Harnett County

Permit Number: BCOM2603-0008

Description: **Auto Retail Shop & Unpermitted 12x16 Prefab Storage Building**

LIST OF REVIEWS

SITE PLAN

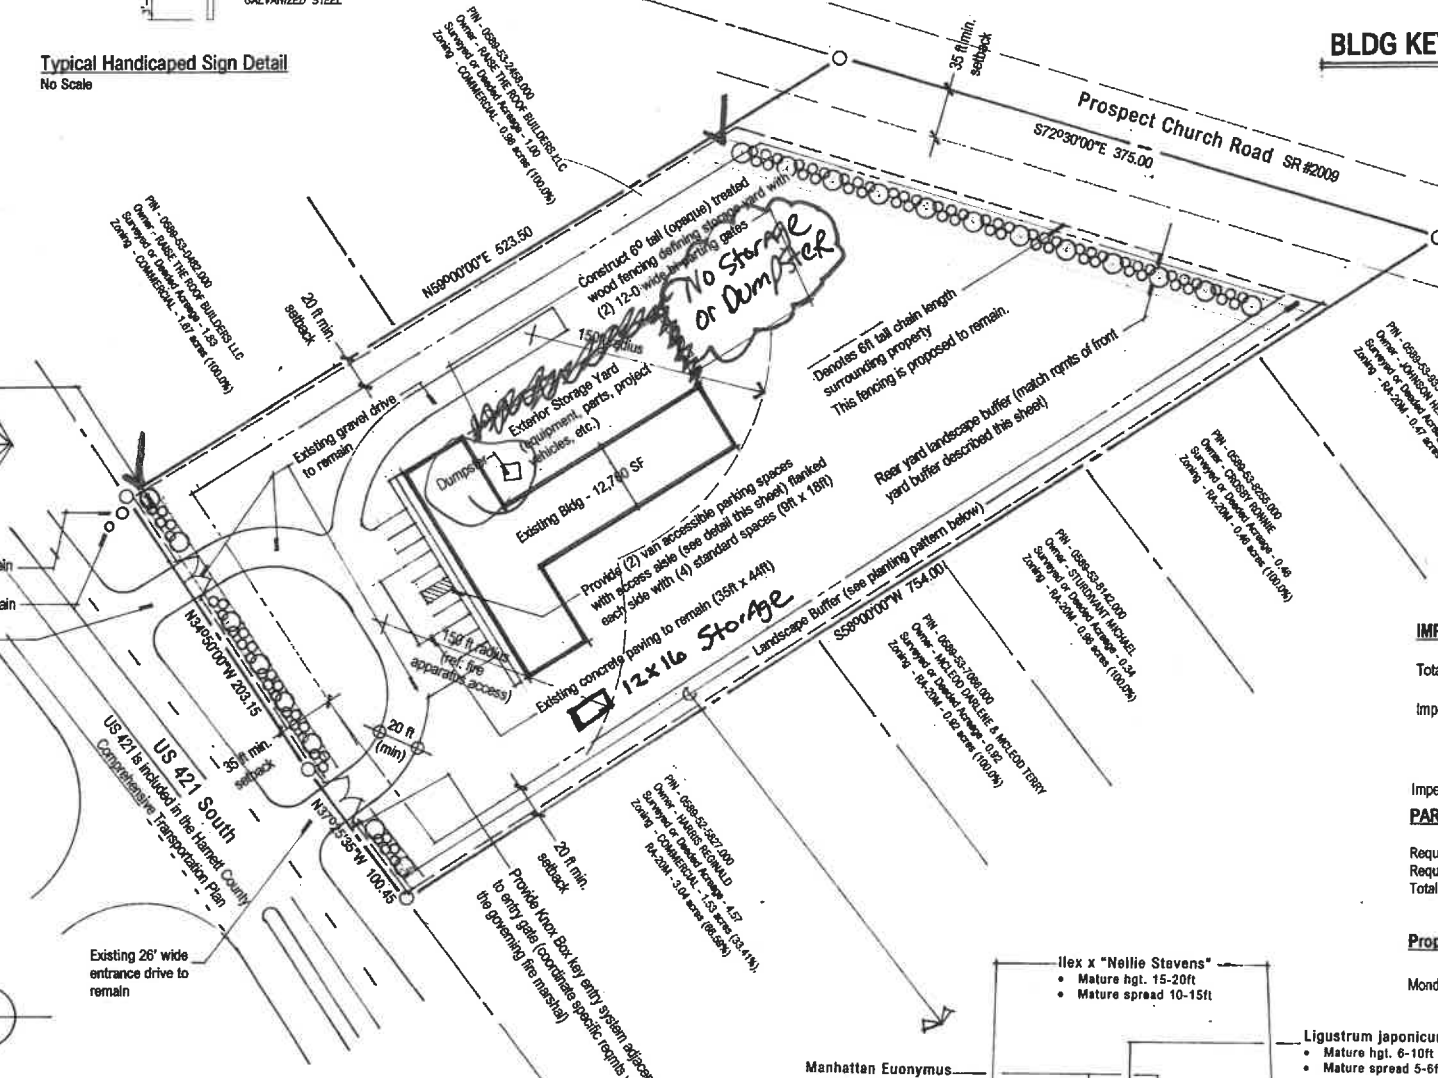
SENT DATE	RETURNED DATE	DUE DATE	TYPE	CONTACT	STATUS	REMARKS
Review Group: 1ST PLAN REVIEW						
3/27/2026	4/10/2026	4/13/2026	FIRE MARSHAL	MATTHEW STARLING	DISAPPROVED	See Comments
Notes: 1. Provide interior layout of the building. 2. No fire extinguishers marked on plans. 3. Garage doors cannot be used as an exit. Please make corrections to the plans and resubmit. MJS						
Review Group: AUTO						
3/27/2026	3/27/2026		COMMERCIAL INTAKE	CP Bucket	APPROVED	SITE2208-0002
Notes:						
3/27/2026	4/1/2026	4/13/2026	COMMERCIAL BUILDING REVIEW	Brad Sutton	DISAPPROVED	
Notes: Need a plan drawn to scale. Cannot count garage doors as exits. Plan must have all rooms in the building shown						
4/1/2026			COMMERCIAL BUILDING REVIEW	Building Bucket		
Notes:
